**From:** Jeff Watson  
**Sent:** Tuesday, November 05, 2013 1:27 PM  
**To:** Christine M. Garcia  
**Cc:** Shelley A. McClellan  
**Subject:** BL-13-00017 Berger

RE: Berger Boundary Line Adjustment (BL-13-00017),

Map Number	20-14-36023-0005	Parcel Number	799234
Map Number	20-14-35014-0001	Parcel Number	535934

38-201

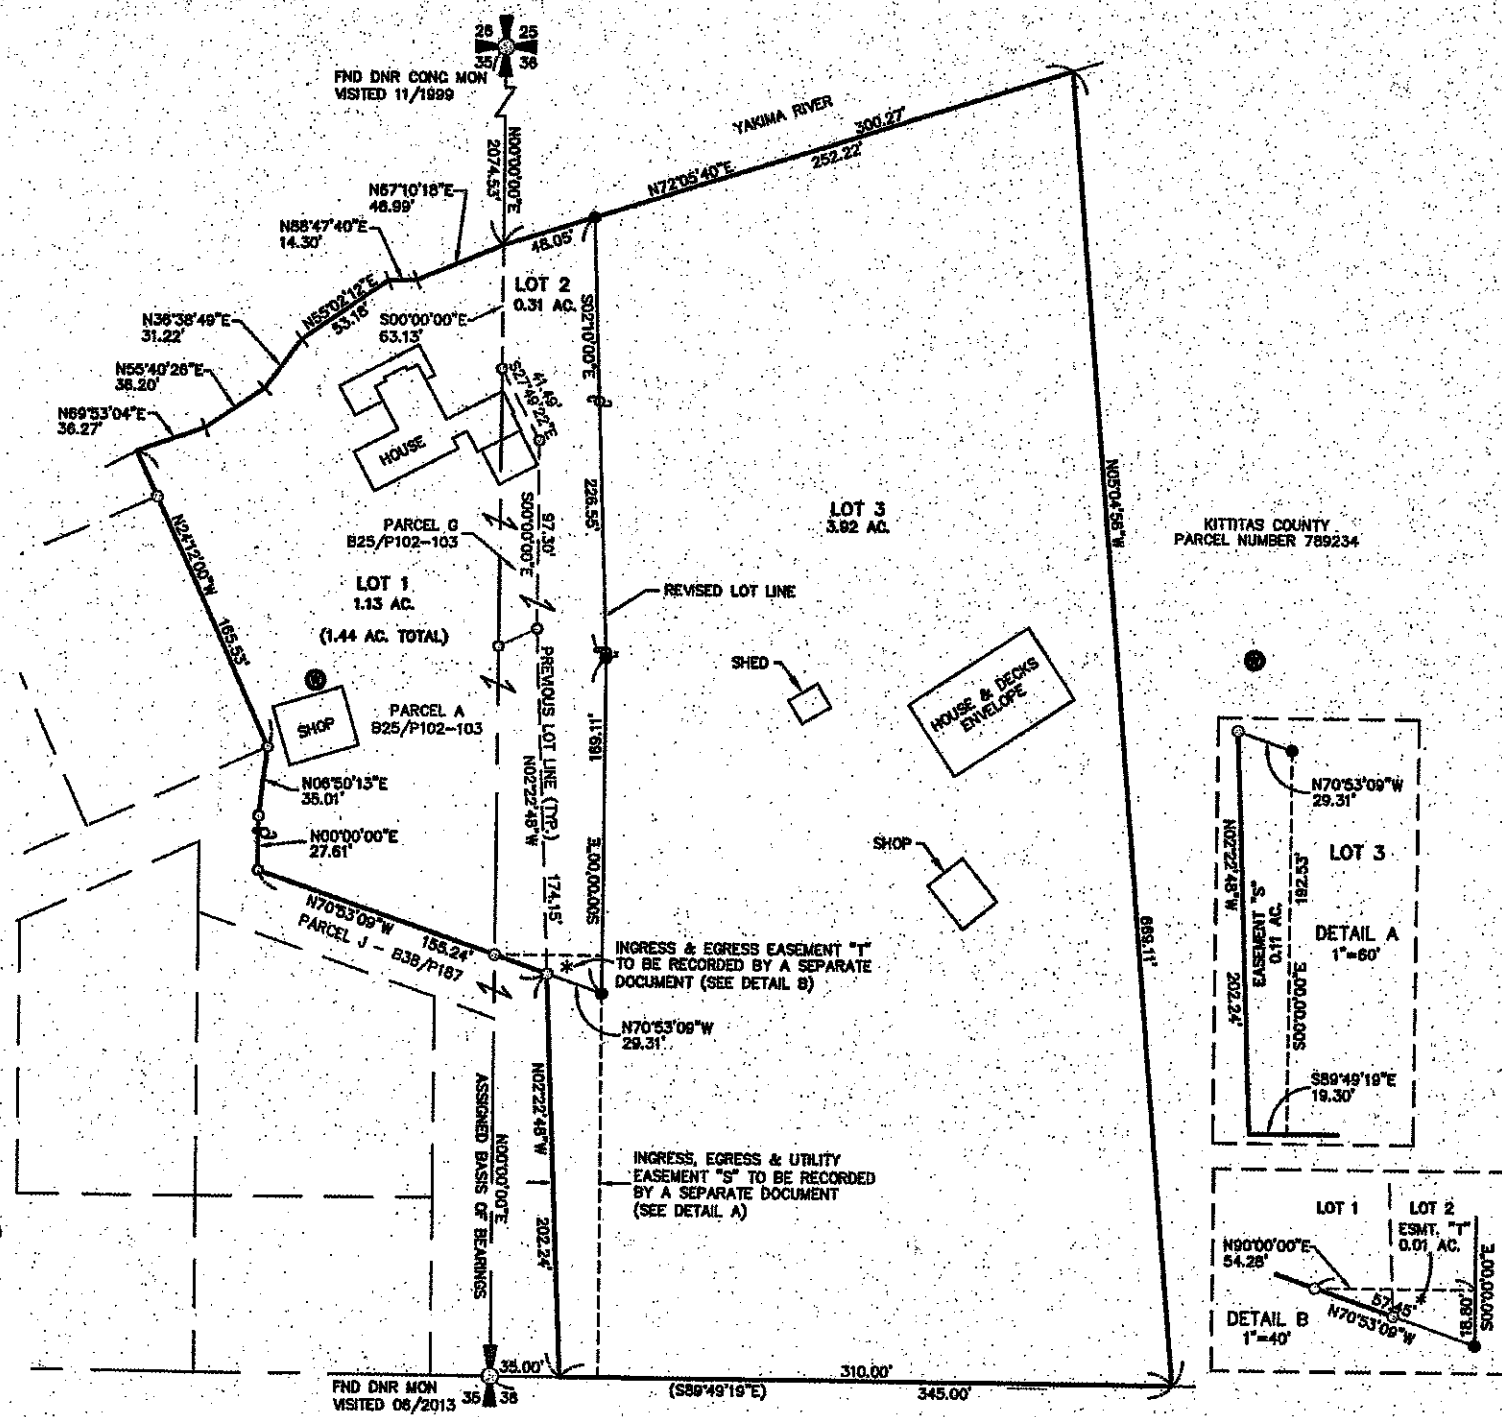
The proposed lot line doesn't interfere with the well next to the shop. I am just curious if it is a shared well situation.

I could have sworn I sent this to you. We need to know where the well is (are) on this one.

Ken Hodge shares a well with the neighbor to the East. That well is shown on the recorded survey on the neighbor's property. The well shown by Mr. Berger's shop is not a shared well. This well is for the sole use of the Berger property. The boundary line adjustment does not affect either well.
